Fritwell Parish Council response to:

Application Number 18/00825/HYBRID

Fritwell Parish Council comments on the above application as follows:

WALKING AND CYCLING STRATEGY

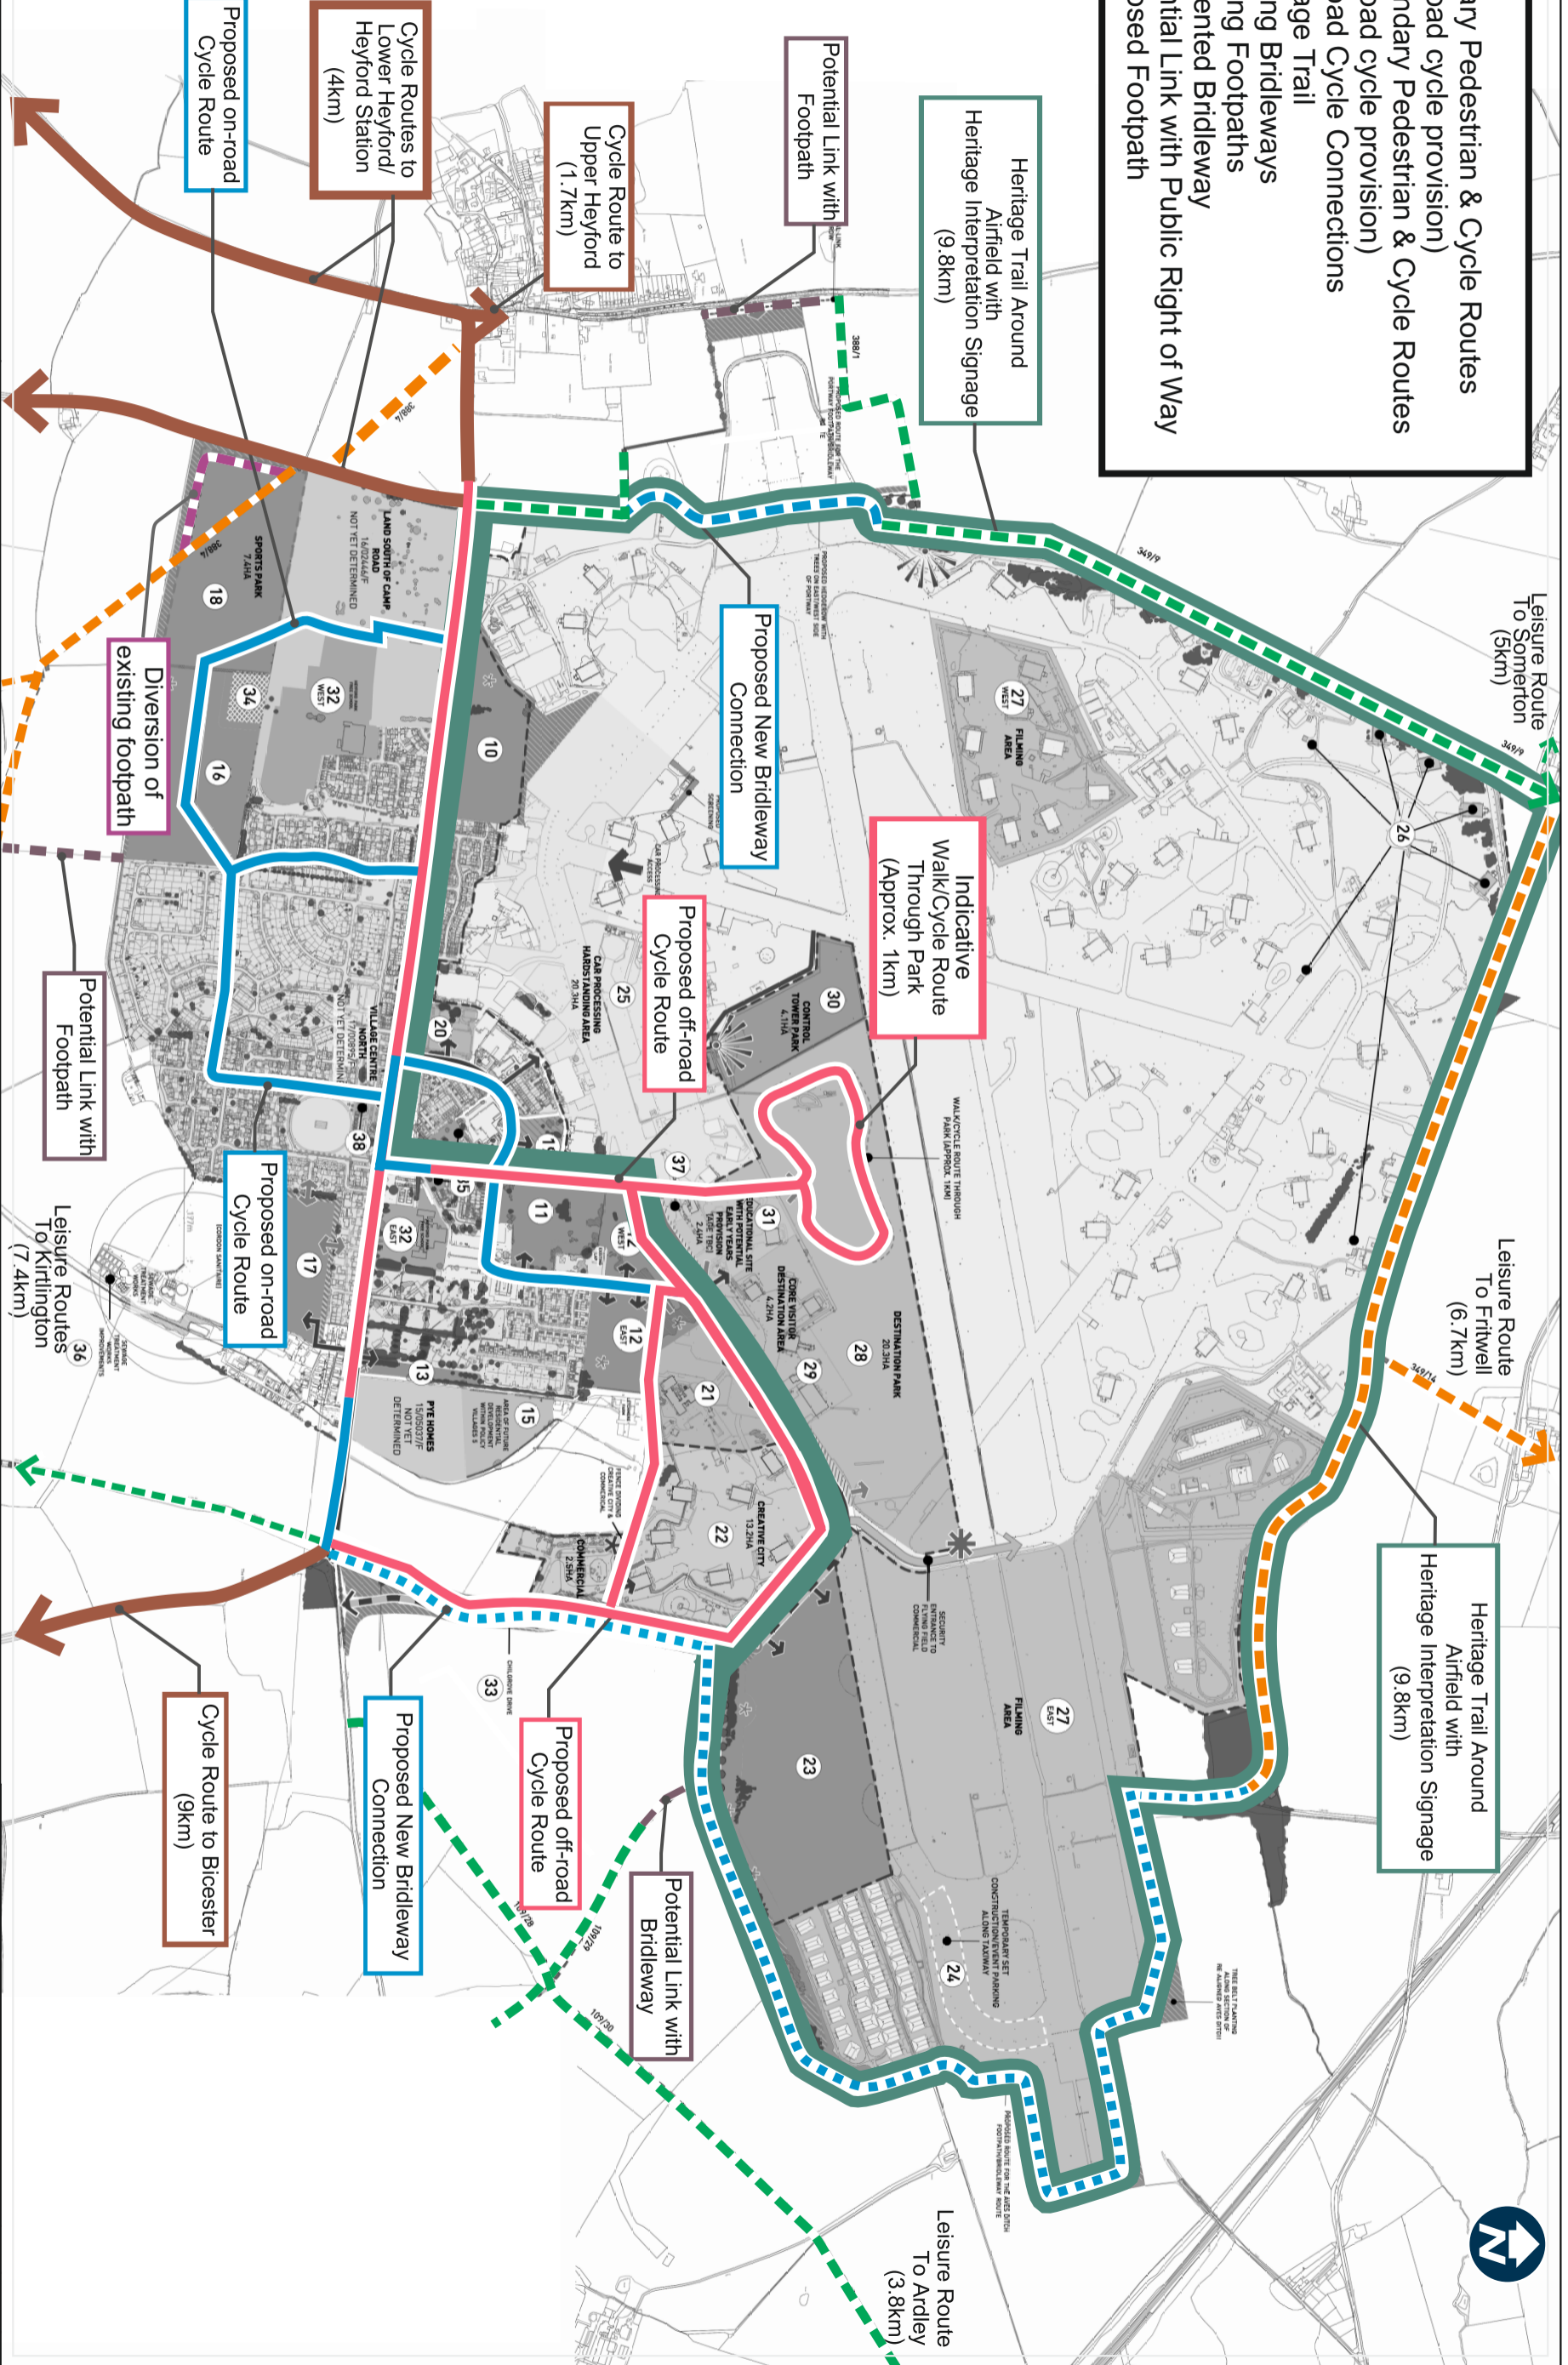
- The design and place shaping principle requires the retention and enhancement of public rights of way and we welcome the opening of parts of the ancient pathways (Portway and Aves Ditch) for people in Heyford Park. However, the map of cycling and pedestrian routes is not clear about how it usefully links and enhances access from outside the HP development. There are concerns about the nature of the Heritage Trail around the site and access by walkers. At the northern edge of the site it describes the trail as using the current footpath, which follows the edge of a field with woodland including significant trees bordering the perimeter fencing. It is hoped that plans do not include fencing the current footpath in any way or the removal of the woodland and natural areas.
